Response to Kirklees Council Consultation Response dated 03/01/23

Land at Lady Ann Road, Soothill, Batley, WF17 0PY: Erection of 67 dwellings with associated works

13/01/23

Landscape Context and Concept Landscape Design

1. Precedent planting
2. Native hedgerow
3. Wild flower meadow
4. Path with planting
5. & 6. Community orchard
7. Wild grasses
8. & 9. Street trees and front gardens

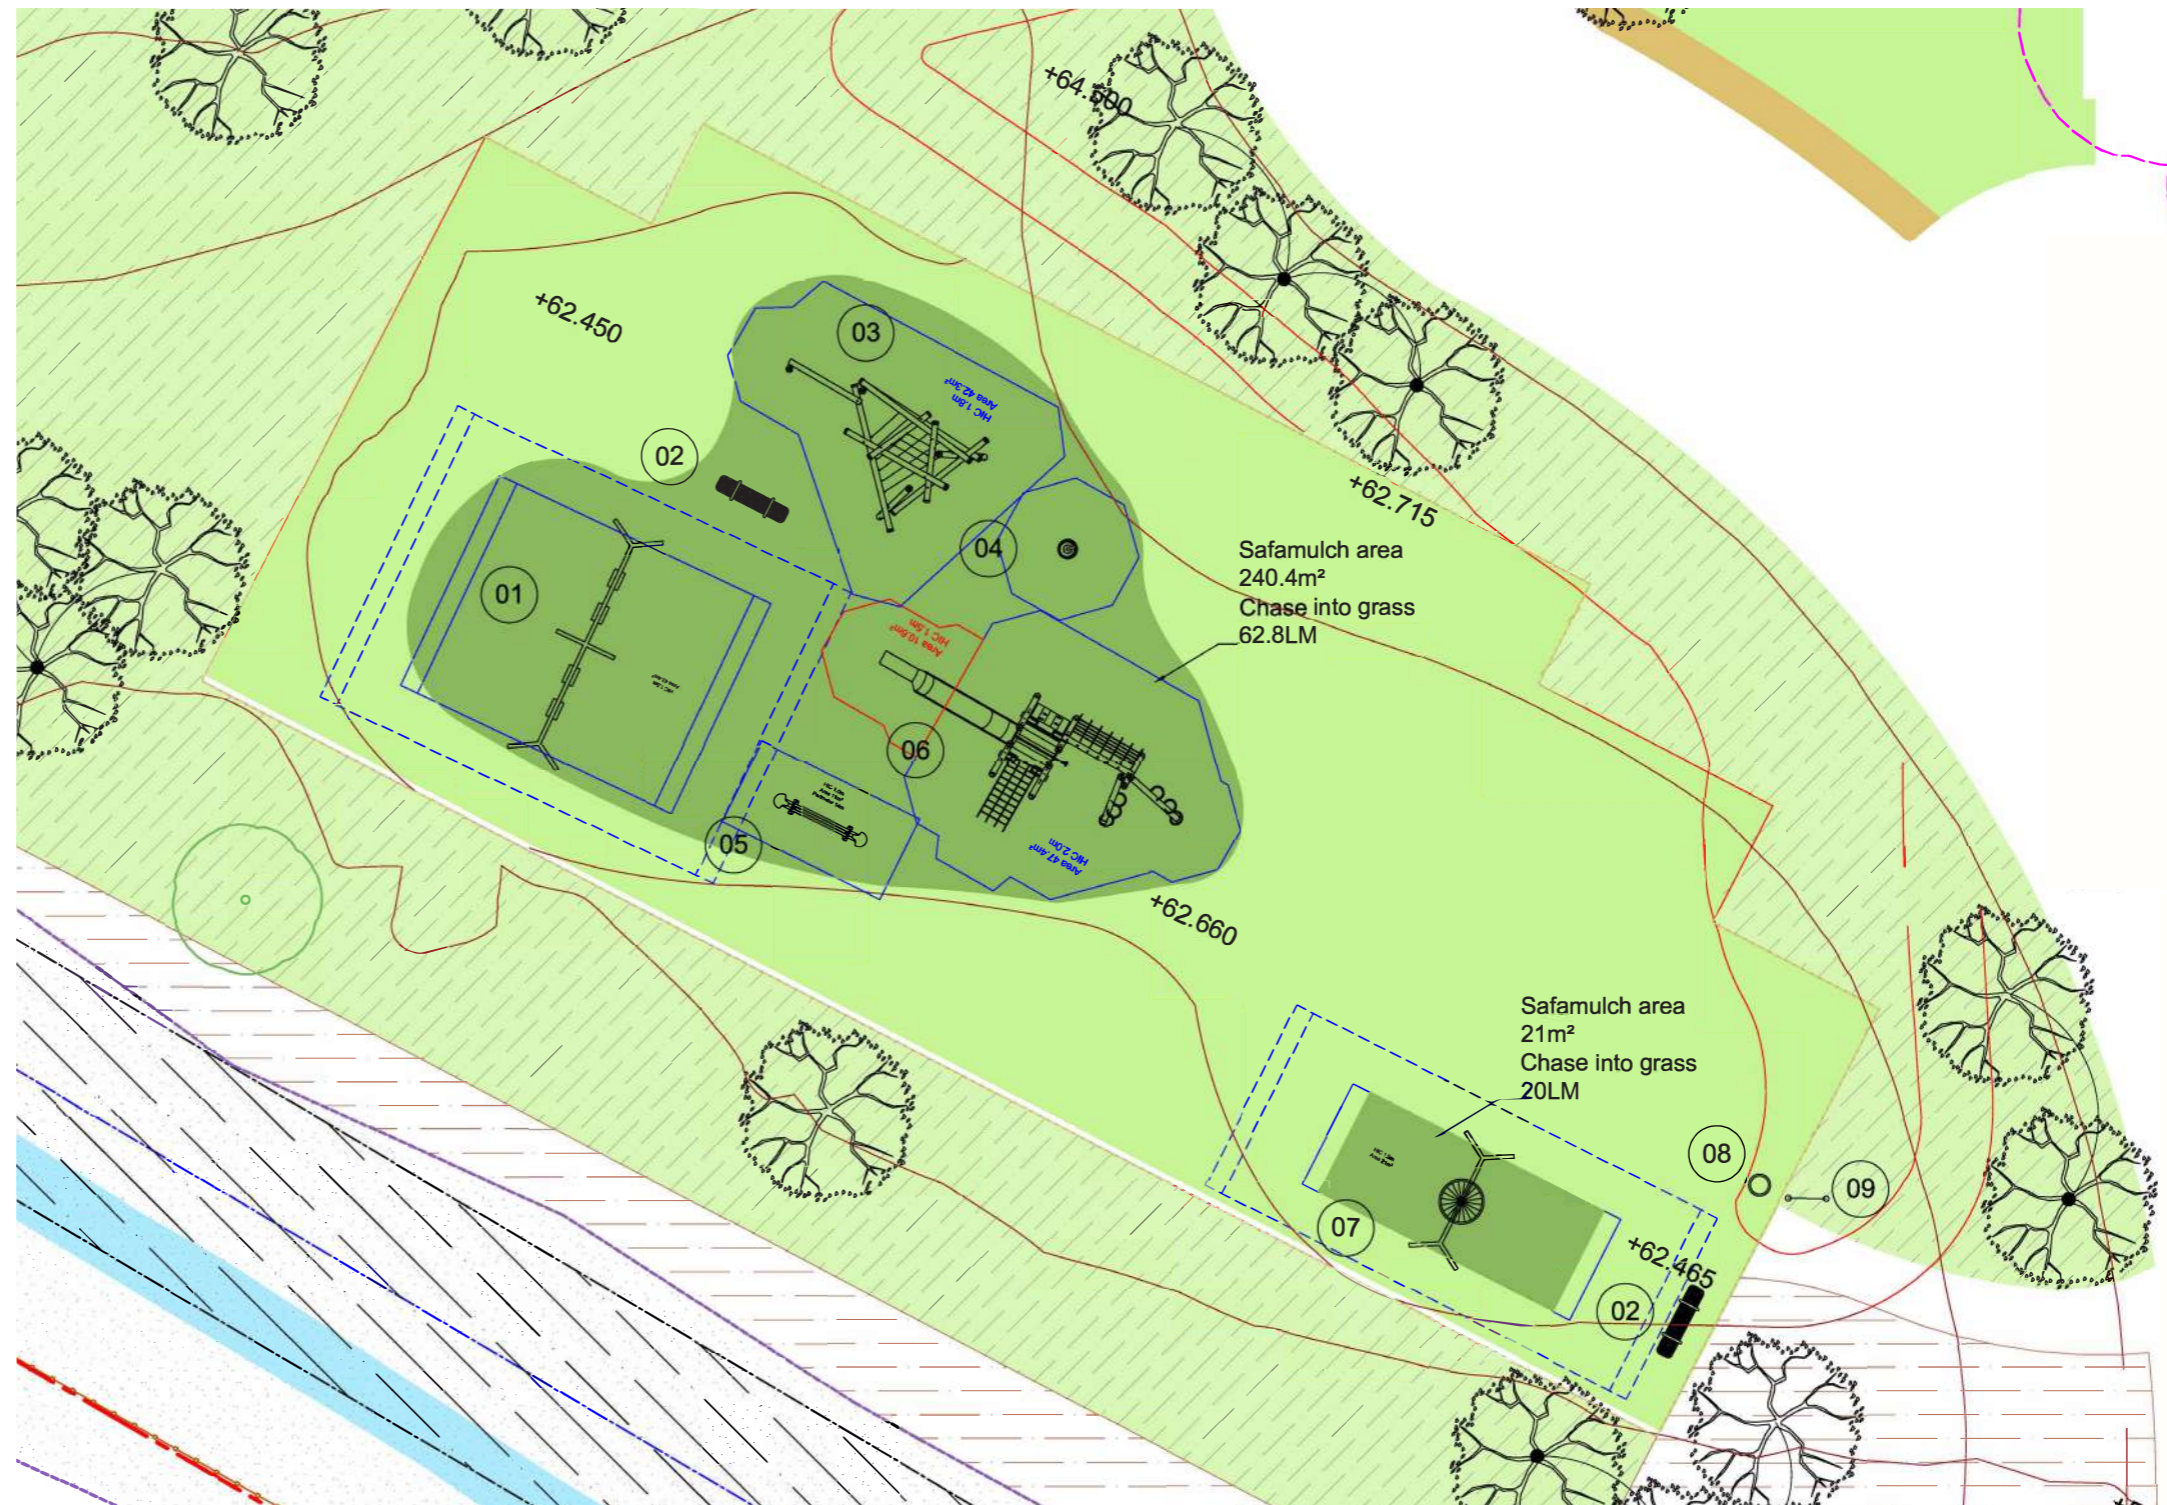
Comments from Landscape Officer	Response
<p><i>In this layout, the trees are in front gardens rather than street trees, possibly due to the constrained space, and whilst tree planting to the frontages are welcome. Proposed tree species and size etc details will be required, also we presume there be root barriers given their proximity to the rear of the proposed pavements and driveways – full details will need to be provided prior to landscape scheme approval. We would not want the proposed trees removed to necessitate s38 road adoption further down the line.</i></p> <p><i>Hedgerows are welcomed to break up the dominance of hard surfaces/car parking to frontages, species, sizes and planting density details will be required.</i></p>	<p>Planting Plans with Plant Schedules providing information on plant species and sizes will be provided.</p> <p>Root barriers to be added to all street trees located alongside highways.</p> <p>Planting Plans with Plant Schedules providing information on plant species and sizes will be provided.</p>

<p><i>The landscaping proposals submitted along with the planning application, are welcomed however, further clarification on proposed species & mixes for elements such as native shrub mix, native & formal hedgerows and trees are requested. In addition, details of the “wildflower meadow on regraded embankments” should also be detailed within the proposed soft landscape plans/specification.</i></p> <p><i>Where possible species included in the Plantlife list of species to avoid should not be included on the plan schedule. Plantlife :: Here today, here tomorrow? / plantlife.org.uk/application Here_today_here_tomorrow_2010_summary.pdf</i></p> <p><i>Community growing area/allotment greenspace on site is welcome, however, consider access to the community growing area – will it be through the play area or from a private road? This new space should meet the needs of the widest possible range of users, be easily accessible and enjoyed by all people, regardless of visual, physical and cognitive ability, mobility or age. Design for the community growing/orchard should consider the equalities Act and accessibility, as should access within the playable space.</i></p>	<p>Planting Plans with Plant Schedules listing the plant species and sizes will be provided. A variety of native and ornamental species will be used. The species mix for the amenity lawn and wildflower meadow will be provided within the Specification and on Planting Plans.</p> <p>Noted.</p> <p>The Orchard is considered to be an informal area of fruit trees with grass beneath. Access to the orchard will be from the Play Area.</p> <p>Proposed levels would ensure the Orchard would be accessible from the Play Area</p>

## Equipment List

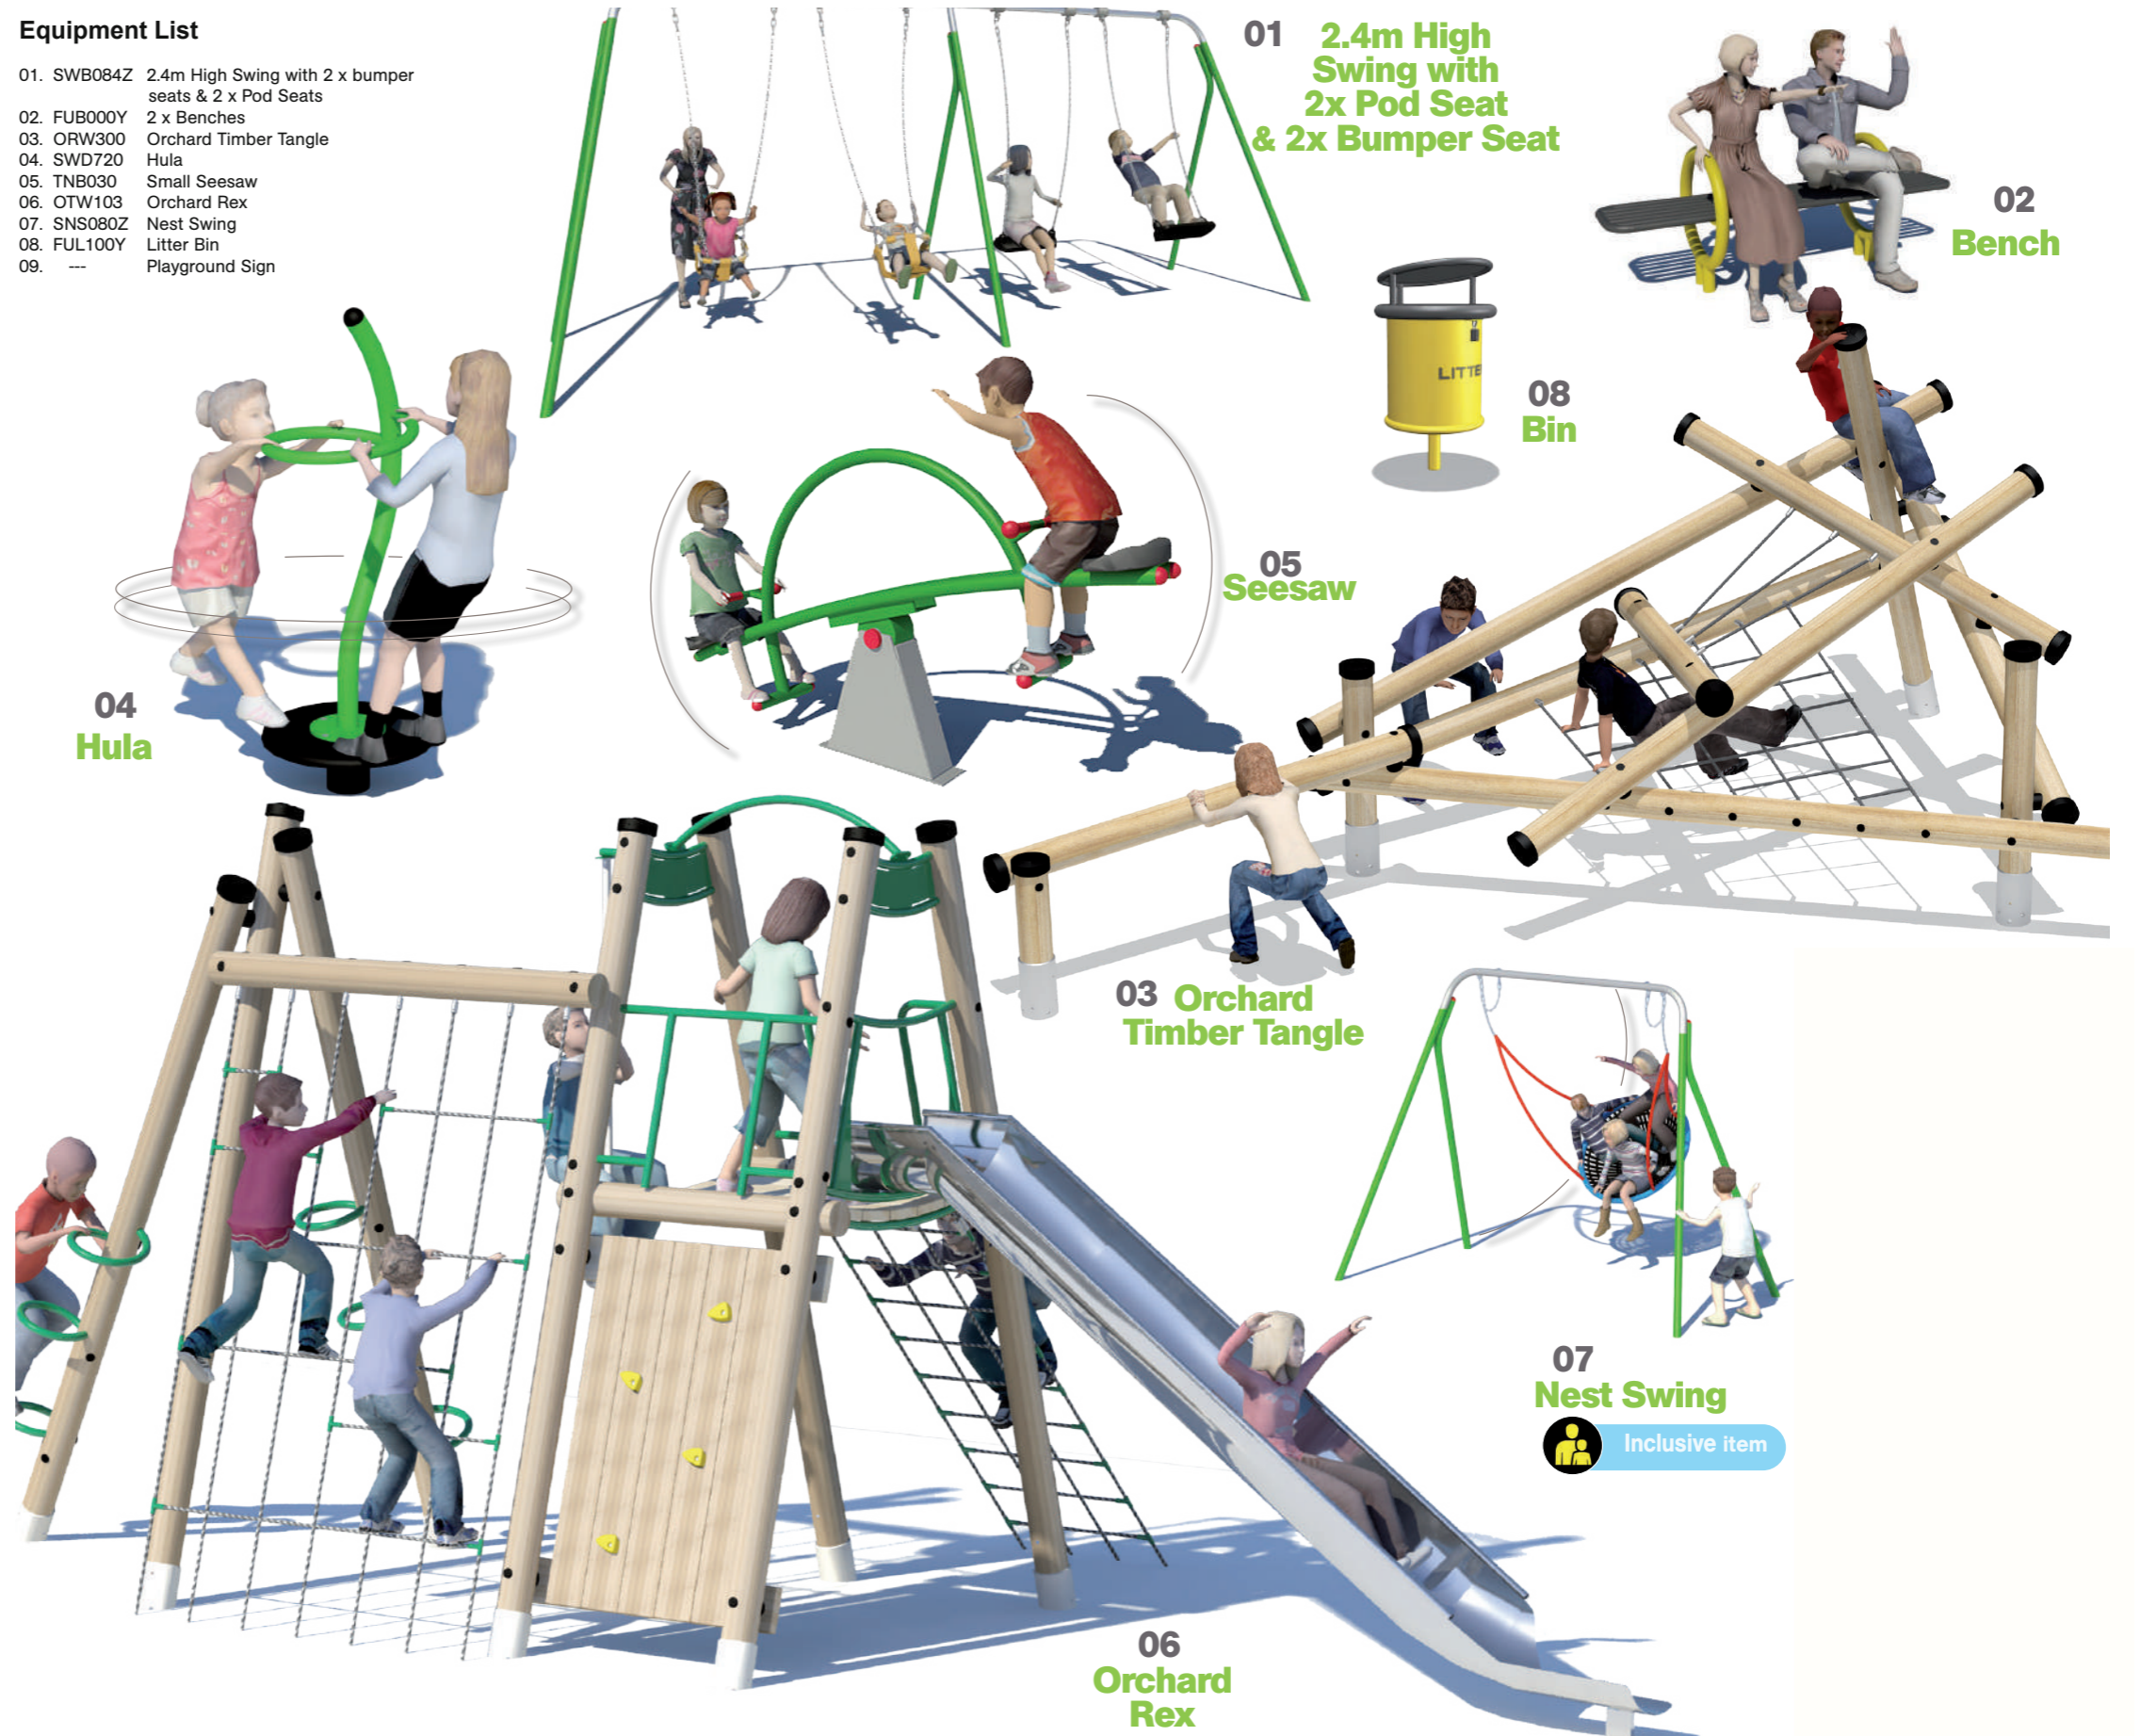
Comments from Landscape Officer	Response
<p>Play Area</p> <ol style="list-style-type: none"> 1. <i>Is it possible to install this play area OVER the attenuation tank as some of the footings for the play items require large concrete foundations?</i> 2. <i>Will there be inspection covers protruding through the safety surfacing?</i> 3. <i>Will it be fully meet BS EN 1176 & 1177 over an attenuation tank?</i> 4. <i>Consider the equalities Act and accessibility- Safamulch is bound and therefore better for access for all, however, getting from the entrance path to the equipment and between the nest swing and the rest of the equipment is over grass which could get muddy and slippery, especially along well worn routes and access points – at the entrances.</i> 5. <i>The play equipment plan – list and location does not show the two entrance points which the Landscape Masterplan and Landscape proposals plan 1 shows. Plans need to be consistent for the s.106 agreement.</i> <p><i>Please clarify.</i></p>	<ol style="list-style-type: none"> 1. The Design Team Engineers have confirmed it is possible to construct the Play Area on top of the Attenuation Tank provided access is provided. 2. Inspection covers are sited in the corners of the Tank, away from the Safety Surface and Play Equipment. 3. The Play Equipment would meet the BS EN 1176, 1177 standards for construction and installation. 4. Safety surface is to be provided. Areas in-between the safety surface are now specified as tarmacadam. An additional area of amenity lawn provided. 5. The attached Play Area plan shows the two entrance paths from the Access Road to be provided.
